CITY OF PORTLAND, MAINE  
DEVELOPMENT REVIEW APPLICATION  
PLANNING DEPARTMENT PROCESSING FORM

2003-0035

98 Edgeworth Ave.

**Approval Conditions of DRC**

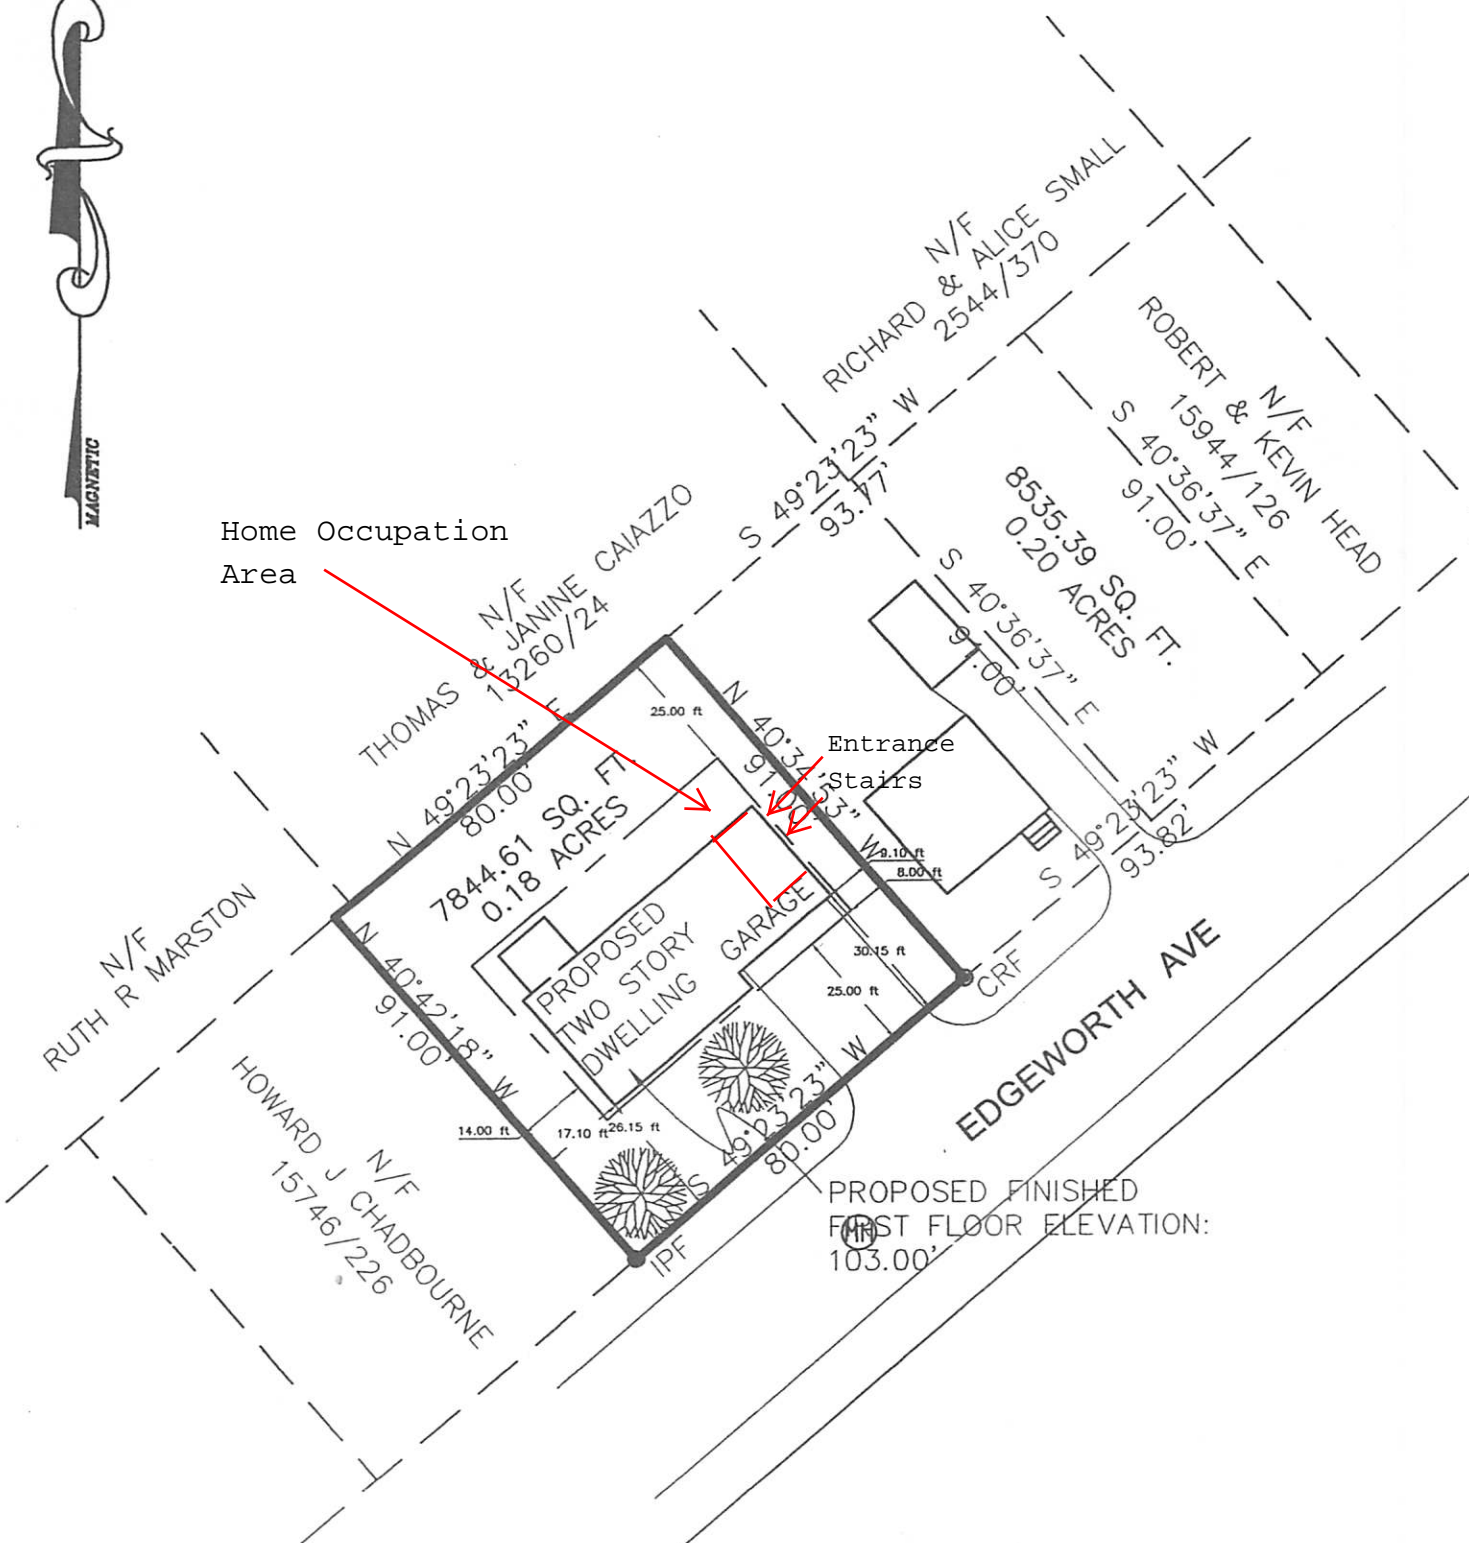
- 1 NO CHANGES TO EXISTING CONTOURS ARE PLANNED, ANY CHANGES IN CONTOURS SHALL REQUIRE REVIEW AND APPROVAL BY THE CITY.
- 2 Two (2) City of Portland approved species and size trees must be planted on your street frontage prior to issuance of a Certificate of Occupancy.

- 8 The site contractor shall establish finish grades at the foundation, bulkhead and basement windows to be in conformance with the first floor elevation (FFE) and sill elevation (SE) set by the building contractor to provide for positive drainage away from entire footprint of building.
